## Points from Issues Specific Hearings 3-7 of relevance for Gravesham Borough Council

(IP ref: 20035747)

### Deadline 4

*Local Landscape Character Area boundaries of the Kent Downs AONB LCA, West Kent Downs, Sub-areas Cobham and Shorne*

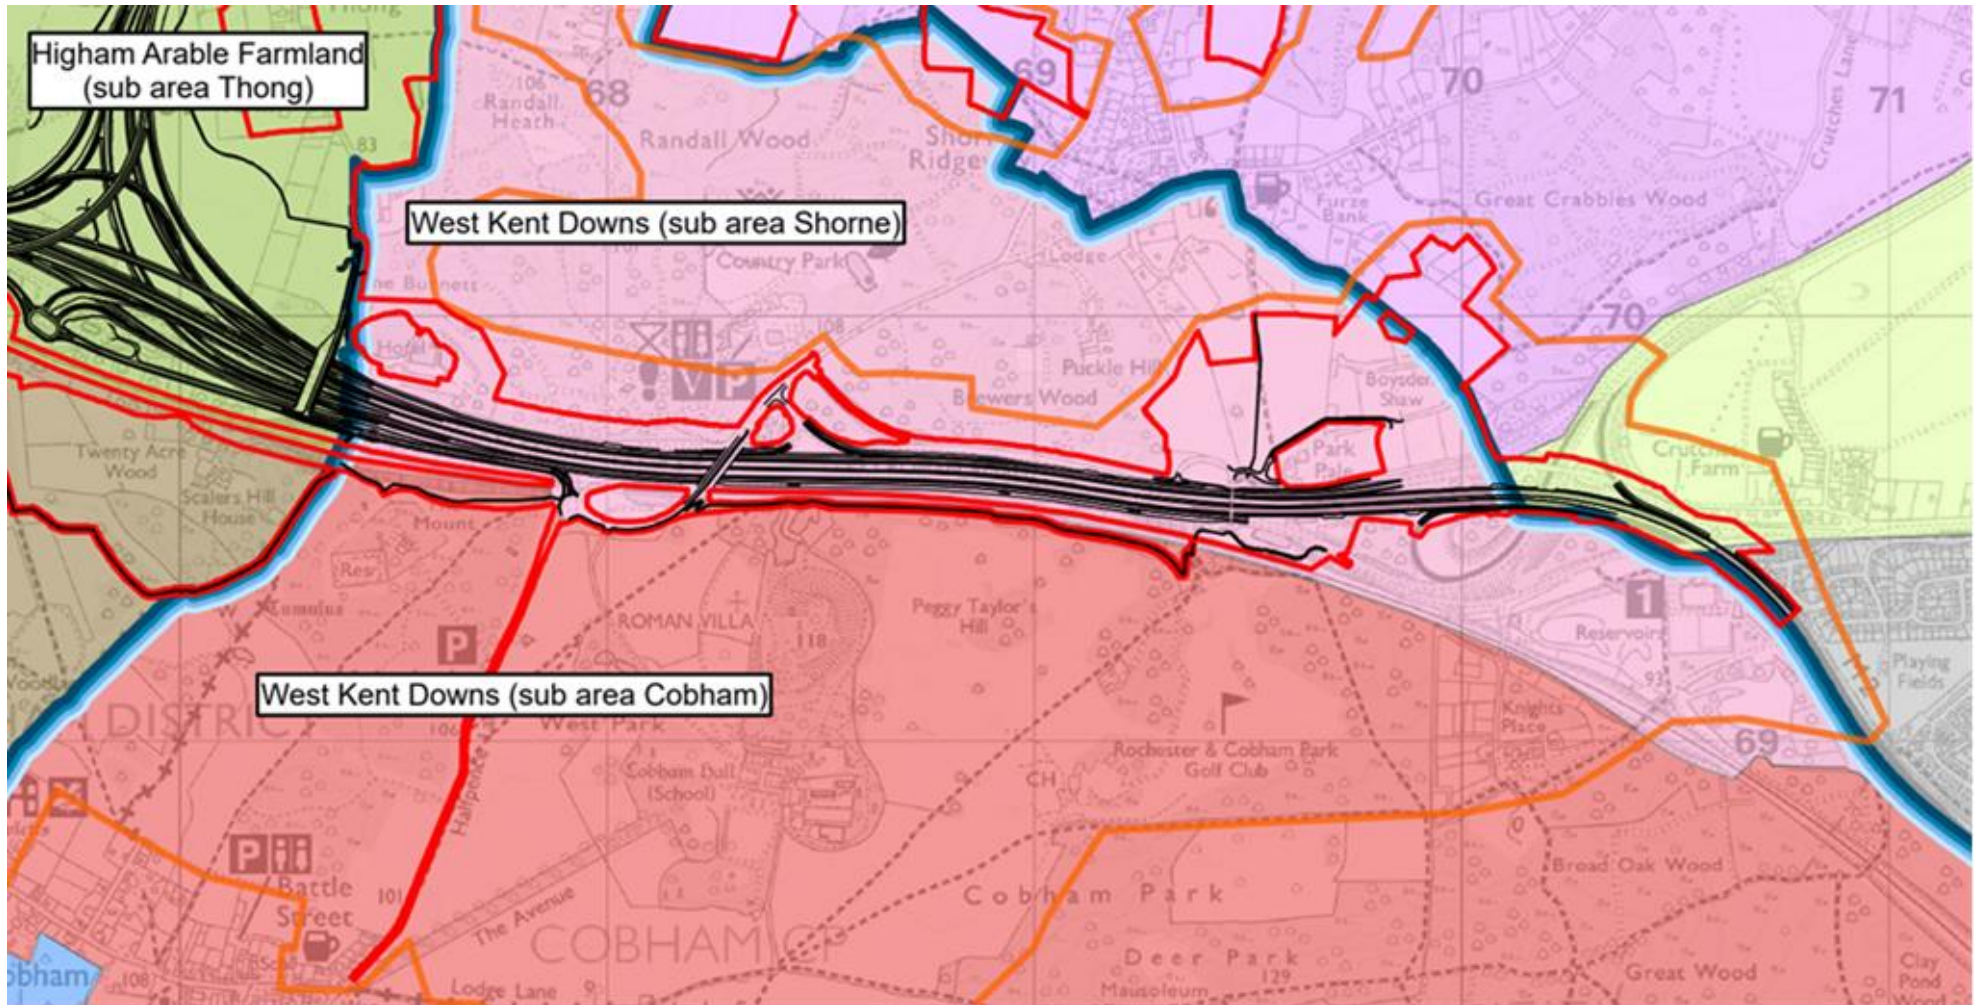
<p>We consider that the design criteria for the green bridges over the widened A2, as set out in document 7.5 Design Principles, are not sufficient to provide adequate mitigation of the adverse environmental effects.</p> <p>Further, the Management Requirements for the green bridges in the oLEMP<sup>2</sup> do not provide the landscape mitigation and enhancement that is needed at these key locations at the boundary of the KDAONB.</p> <p>The oLEMP (REP3 – 107) Section 5.6.2 describes ‘...<i>green bridges at Brewers Road and Thong Lane over the existing A2 are proposed as ‘lightweight’ green bridges, with the green bridge at Thong Lane over the A122 defined as a ‘heavyweight’ green bridge with tree planting.</i>’</p> <p>We consider the green bridges should be made as wide and deep as is necessary to ensure the bridges are fit for purpose and allow the full range of functions to be performed.</p> <p>To set this in context, the A2 corridor currently runs east-west through the KDAONB and forms a barrier across the AONB in this area. However, the effects of this ‘break’ in the landscape are reduced by the existing wooded character along the road corridor, and access is enabled via existing bridges.</p> <p>The central reservation plays a key role in providing areas of wooded planting that contribute to the landscape character and effectively reduce the real and perceived break in the landscape; softening the impact of traffic and reducing the scale of the road. Woodland planting extends along both sides of the A2 and along the HS1 route, extending into the woodland and parkland areas to the south.</p>

<p>The proposals for widening the A2 are difficult to accommodate, as they have to be made within a constrained corridor. As a result, the landscape will be dominated by the road and its hard infrastructure. The increased width of the road, its noise and visual intrusion, and the stripping-out of woodland planting will exacerbate the separation of the KDAONB and dramatically alter the landscape character.</p> <p><b>There are very few opportunities to mitigate or compensate for the effects of the Project in this designated landscape. In the absence of other mitigation measures, the proposed green bridges over the widened A2 are the only opportunity to address landscape severance, and reduce the impacts of the road on wildlife, people and the landscape.</b></p> <p>The A2 bridges should provide a number of important functions. We consider the landscape and access functions of the bridges have not been fully recognised or assessed, given the predicted negative effects of the Project, and the uses of the bridges.</p> <p>The bridges across the A2 are key elements in the recreation access network. They link across the KDAONB and provide connections to the suite of countryside recreation areas situated on both sides of the A2. They are used by walkers, cyclists and horse-riders. The proximity of the widened road, its visual intrusion and noise will be experienced at close quarters.</p> <p>The Design Principles<sup>3</sup> promise ‘<i>a high-quality experience for users...</i>’ but it is our opinion that the current proposals will not deliver on this promise. The bridges are too narrow to provide the protection and screening needed for the range of uses and users.</p> <p>In landscape terms, there is a need and an opportunity to reduce the apparent width of the transport corridor and provide a land bridge to connect the severed landscape at each end of the KDAONB along the A2 corridor. The proposed design principles for the bridges include ‘<i>To act as local landmarks and signal entry into the Kent Downs AONB for drivers... and... vegetation... visible on the horizon....</i>’ The bridges need to do more than</p>

<p>'signal entry' at these key locations where the landscape is undergoing change.</p> <p>In addition to the above functions, the bridges are part of the highway network, and provide road links across the A2. <b>It is our opinion that this combination of uses of the bridges has not been fully considered or assessed.</b></p> <p>In addition, the existing bridge at <b>Park Pale</b>, to the east of Brewers Road bridge, is located at the eastern boundary of the KDAONB. Given the location of this bridge, and the adverse effects reported for this LLCA<sup>4</sup> in the LVIA<sup>5</sup> for both landscape and visual receptors, we consider the Park Pale bridge should also be a green bridge.</p> <p>We consider the term 'green bridge' may be misleading, as the requirement for the bridges makes them multi-purpose and therefore multi-functional.</p> <p>The Applicant states they have considered the guidance for developing green bridges, provided by Natural England<sup>6</sup> and the Landscape Institute<sup>7</sup>. The starting point for the L.I. Technical Note is the NE Review, which is then built on to examine, inter alia, the wider benefits of green bridges.</p> <p>The guidance is an important tool in the development of green bridges, but it is not prescriptive. What is clear from the guidance and the examples provided, is that elements of the designs and lessons from the uses of other green bridges may be applicable in informing the design of the green bridges over the widened A2.</p> <p>The Summary of Findings from the NE guidance document recommends the planning of a green bridge should not be done in isolation, but should form part of a <b>wider mitigation strategy</b>. The Summary also states that the size and structure of the bridge should be based on the requirements of the expected use.</p>

<p>In conclusion, it is clear that the consideration and design of these bridges is a complex area that needs careful analysis.</p> <p>We suggest a careful reappraisal is required to determine whether the designs of the Green Bridges meet the Applicant's proposed key functions; to ensure the proposals are fit for the purposes including, providing a gateway to the AONB, addressing landscape impact and severance mitigation, providing access for pedestrians, cyclist and equestrians that is a high-quality experience, as well as ecological connectivity.</p> <p>Further, we consider that the design of the bridges should be reviewed, and the principal of enhancement is included, at these critical and sensitive locations.</p>
13	Gravesham	<p><b>Adequacy of surveys</b> Provide comments on the adequacy of the surveys set out within the Outline Landscape and Ecology Management Plan [<a href="#">REP3-106</a>].</p>	<p>The oLEMP includes land parcels within the Order Limits that perform landscape and ecological mitigation and compensation functions. It is unclear to us what is meant by 'adequacy of surveys', but as the Hearing is concerned with terrestrial biodiversity, we suggest that Natural England are asked for comments on this point. The Nitrogen Deposition sites need to be fully surveyed for biodiversity, utilities (power line are obvious), archaeology and other features that may impact on the role they can perform.</p>
